M4 Smarter Motorway – Response from RBWM

Drawing title: **SIDE ROAD PLAN & PROFILE REGULATION 4(2) (e) SHEET 1 OF 13 ASCOT ROAD**

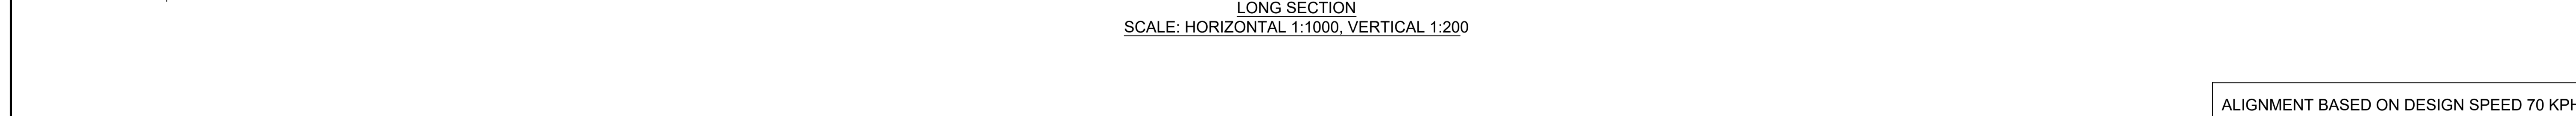
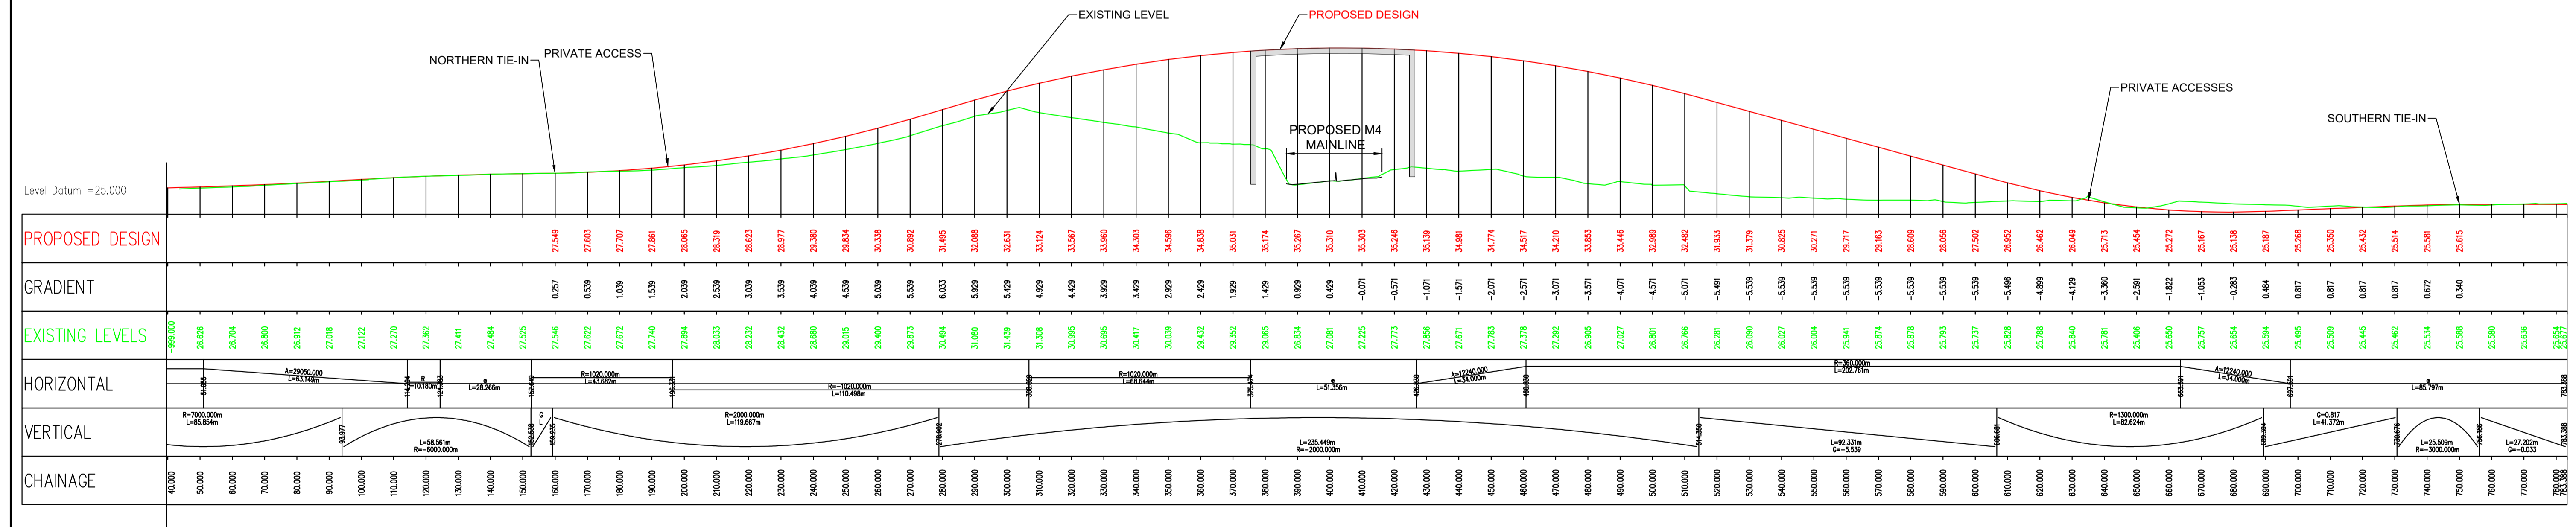
The decision to provide offline new bridges at A330 Ascot Road, Monkey Island Lane, B376 Datchet Road and Ditton Court Road is welcomed as this will reduce traffic disruption during construction for local residents.

Drawing title
SIDE ROAD PLAN & PROFILE
REGULATION 4(2) (e)
SHEET 3 OF 13
MARSH LANE

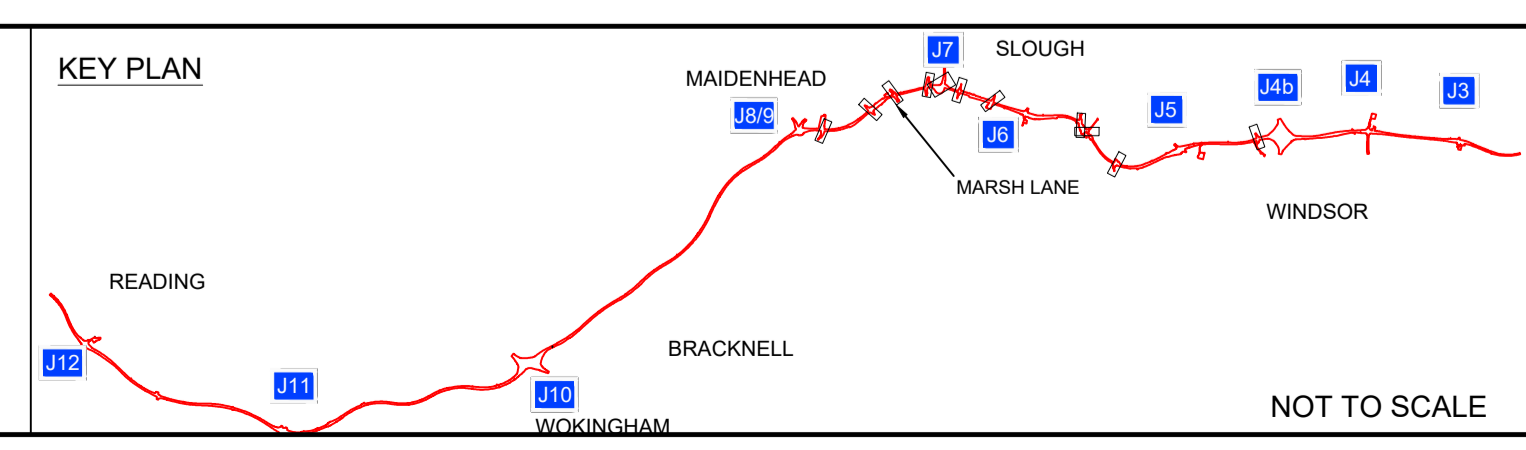
- Marsh Lane (Bridge 3 on consultation plan)

This forms part of an aspiration to improve horse riding in this area, in particular the forum is working towards a Multi-Use Route that will utilise this bridge. This area is heavily used by horse riders. Modifications are needed to this bridge to make it easier for use by horse riders which could easily be folded in to the design of the Highways England works, including building in a sufficient verge width and installing higher parapets on the bridge. The forum suggests that the BHS are consulted regarding the detailed design of the bridge.
